11 April 2019

RJC:KV15-166

**Re: State Significant Development Application: SSD 7693
InterContinental Hotel and Transport House
Response to request for additional information**

ITEM A

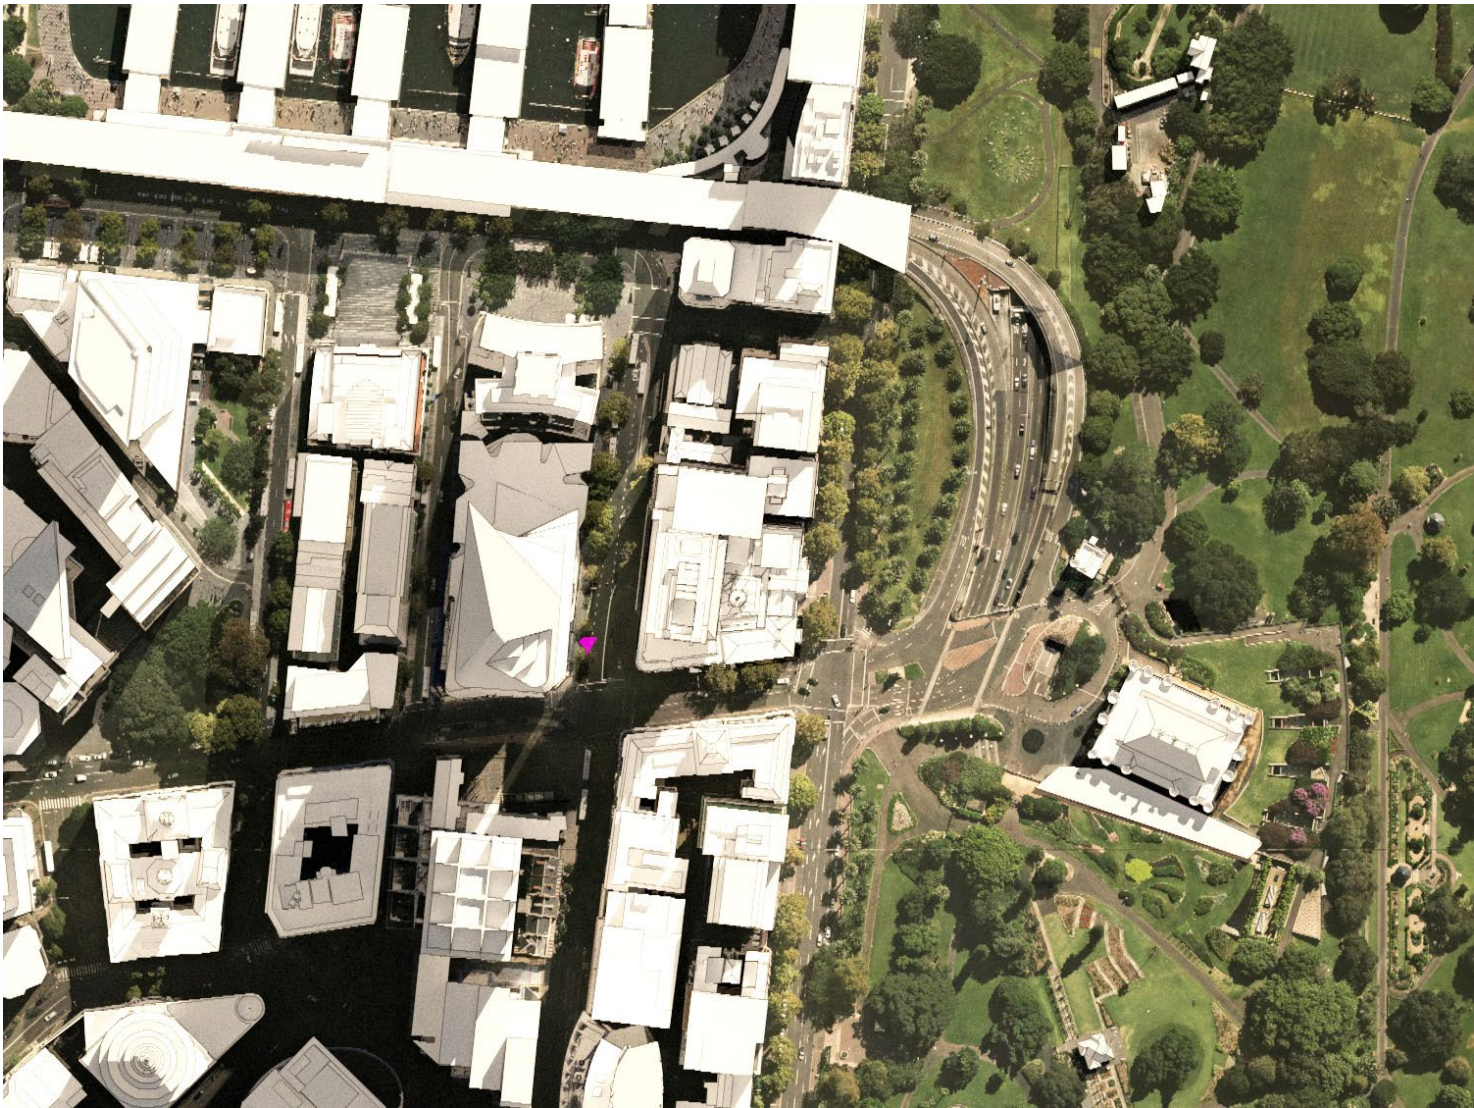
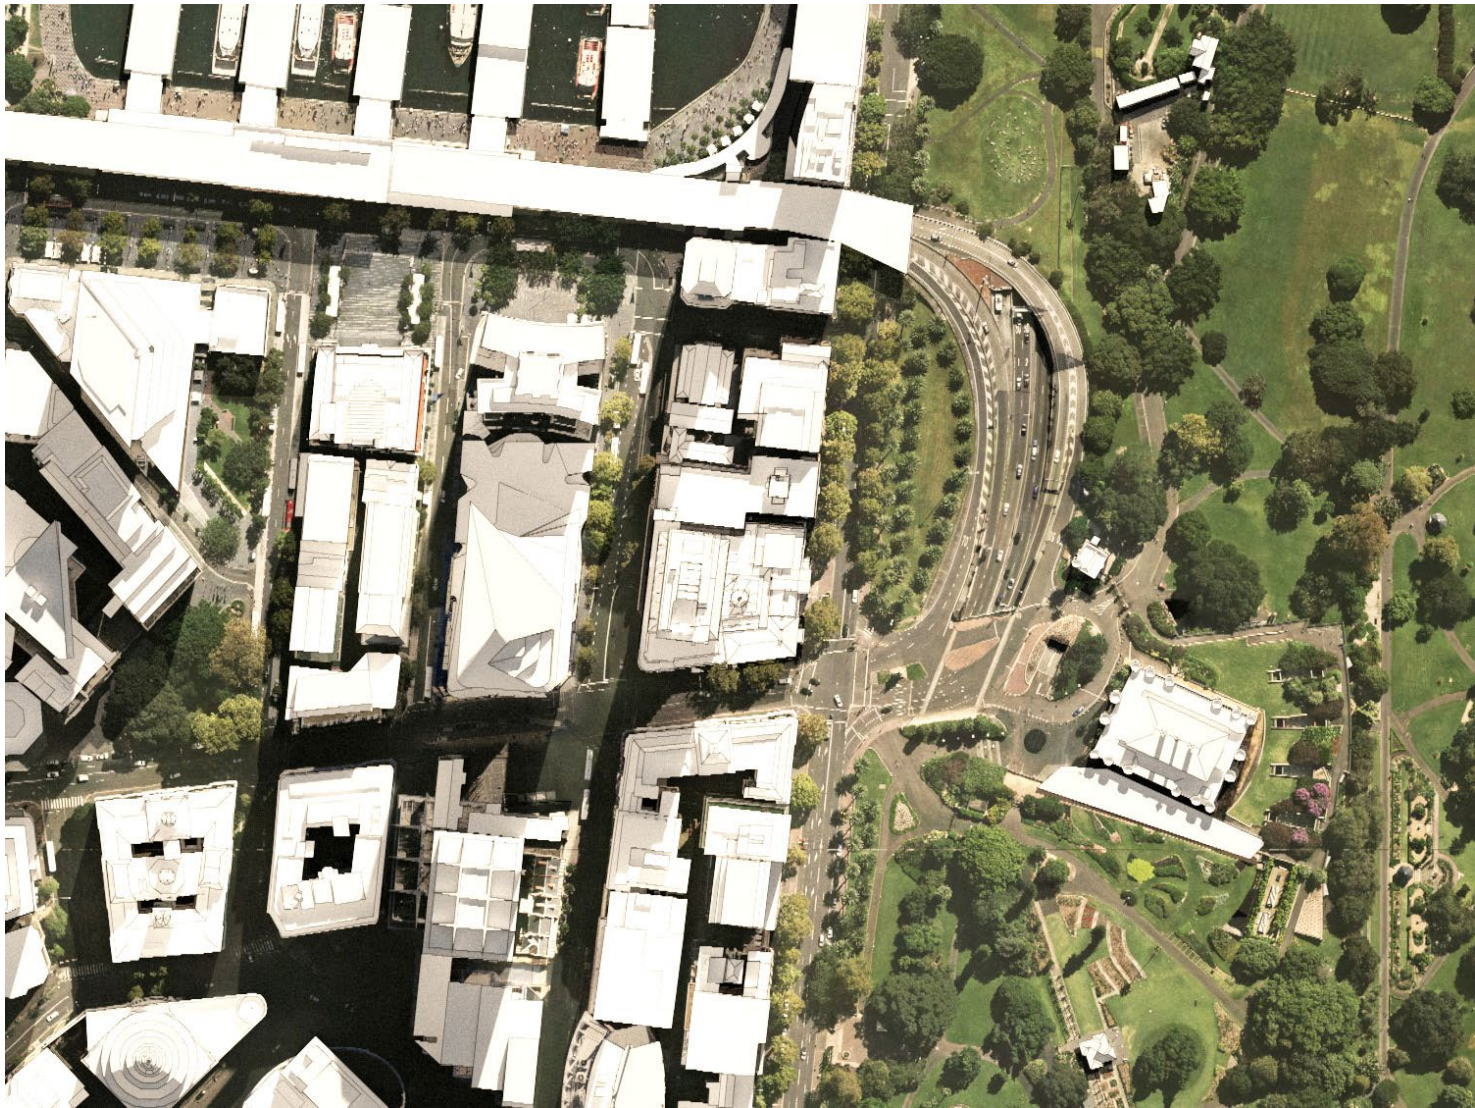
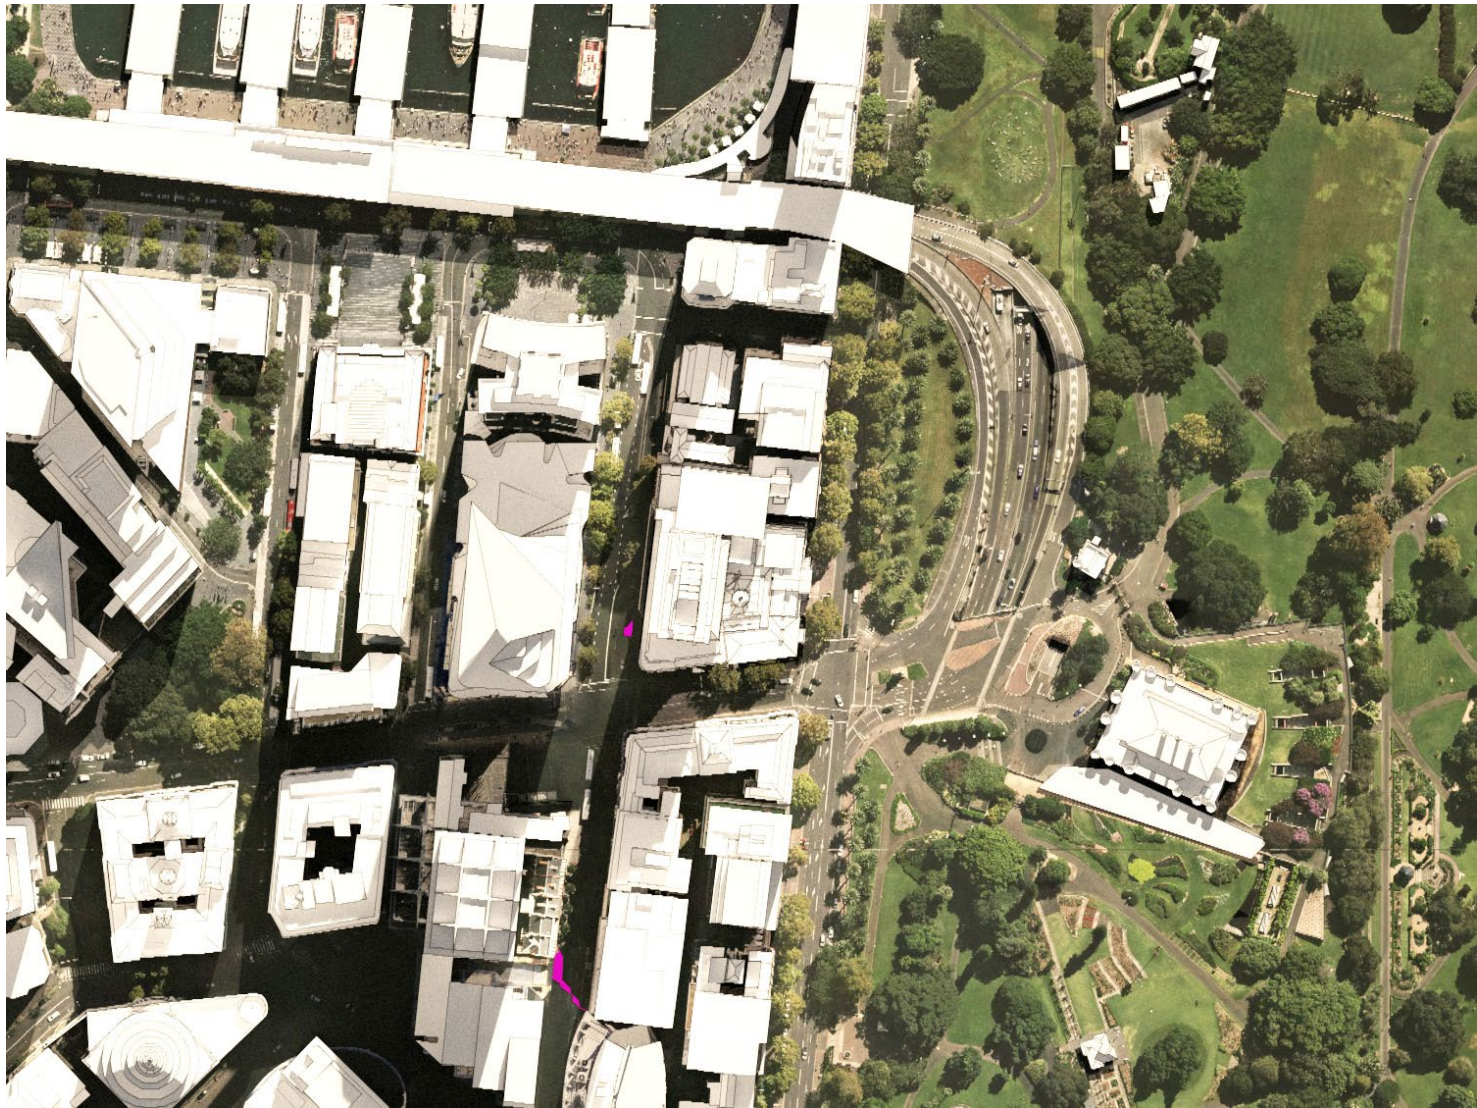
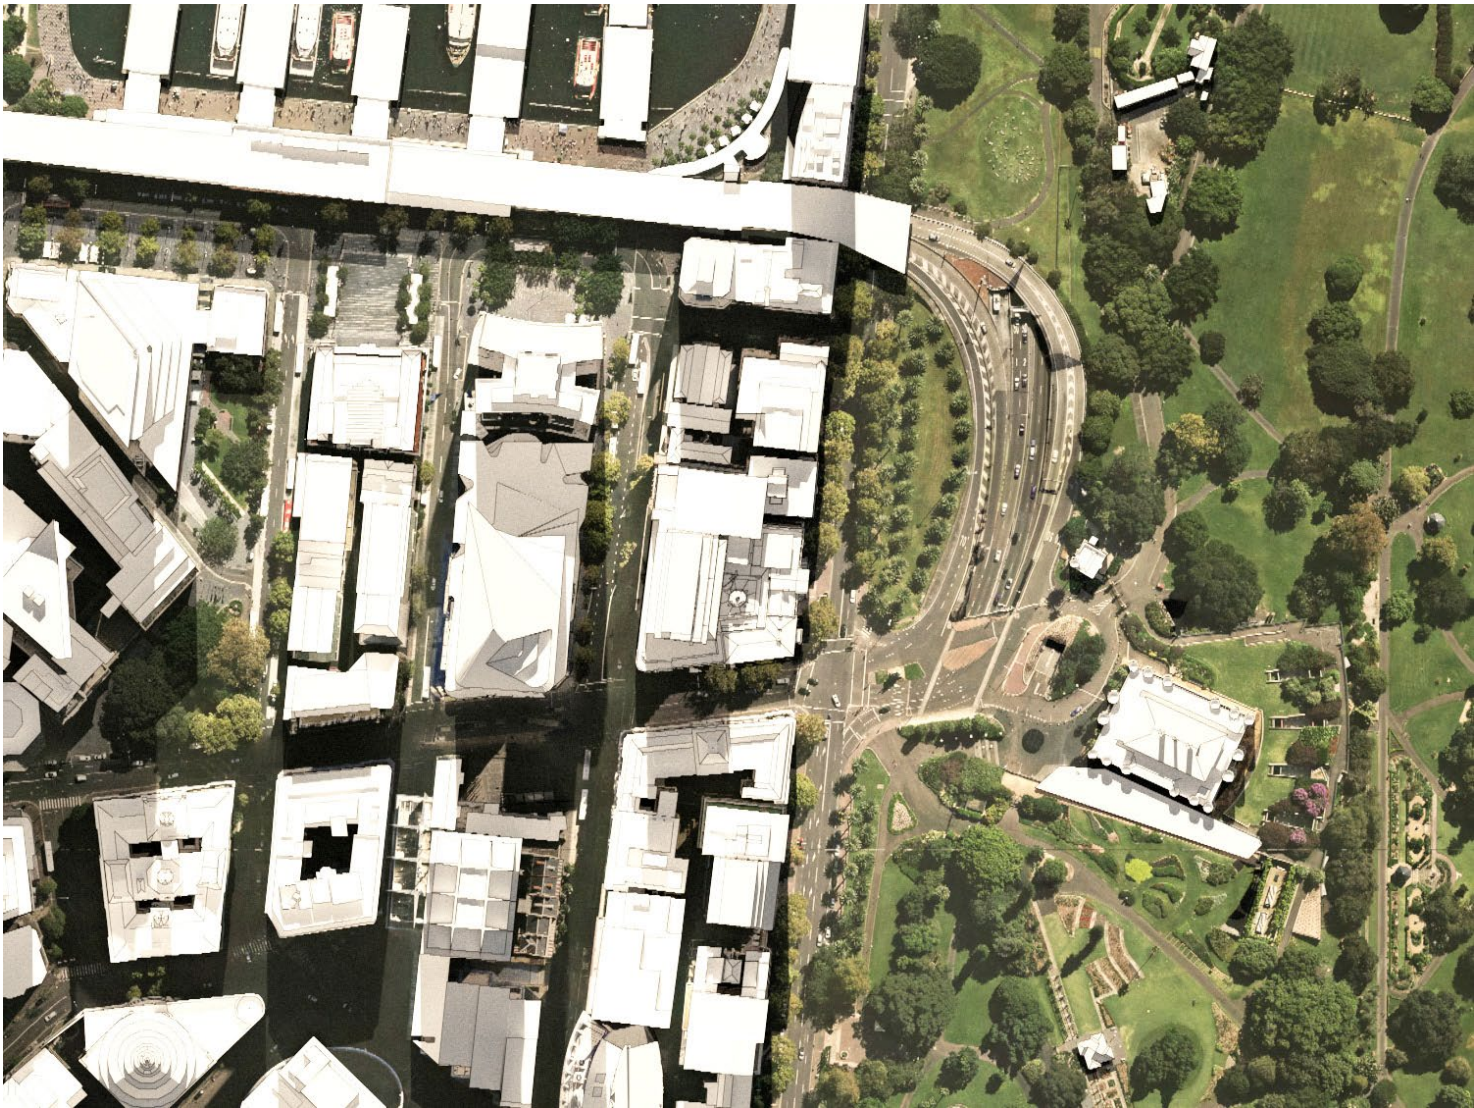
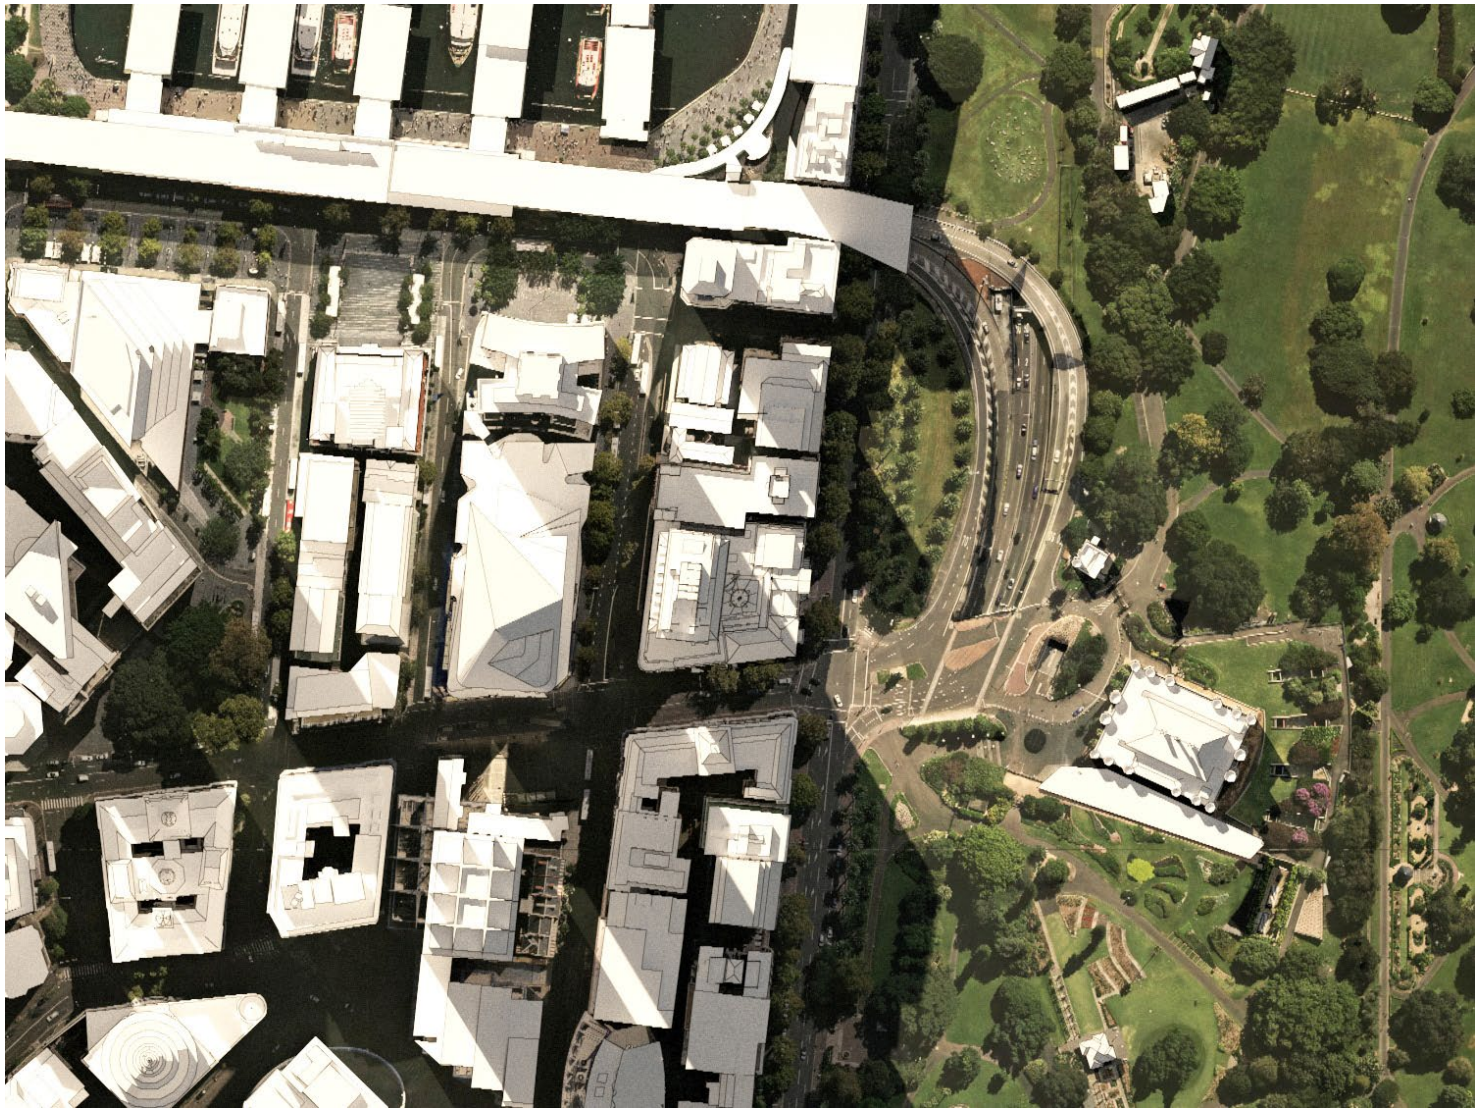
- (a) The shadow diagrams submitted are difficult to interpret. Revised shadow diagrams are to be submitted in a similar format to those prepared by Hassel Architects (example shown below). The shadow diagrams are to be overlayed with an aerial image and any additional overshadowing caused by the proposed building envelope when compared to existing development is to be shown in red.**

- (b) Shadow diagrams are to be provided in hourly intervals from 9am to 4pm for the winter solstice. In addition, shadow diagrams for half hour intervals are to be provided from 2pm-4pm on winter solstice in order to clearly understand the overshadowing impact to the Royal Botanic Gardens. The extent (i.e. duration and area in m²) of overshadowing to the Royal Botanic Gardens (RBG) shall also be quantified.**

Response: Shadow diagrams have been prepared consistent with the previous presentation format as requested by the Department – see Shadow Presentation Items A, B and C provided in **Attachment 1**.

Response: Shadow diagrams have been provided for the requested intervals 9am to 4pm at the Winter Solstice – see Items A (Hourly 9am to 2pm) and B (Hourly and half-hourly 2pm to 4pm).
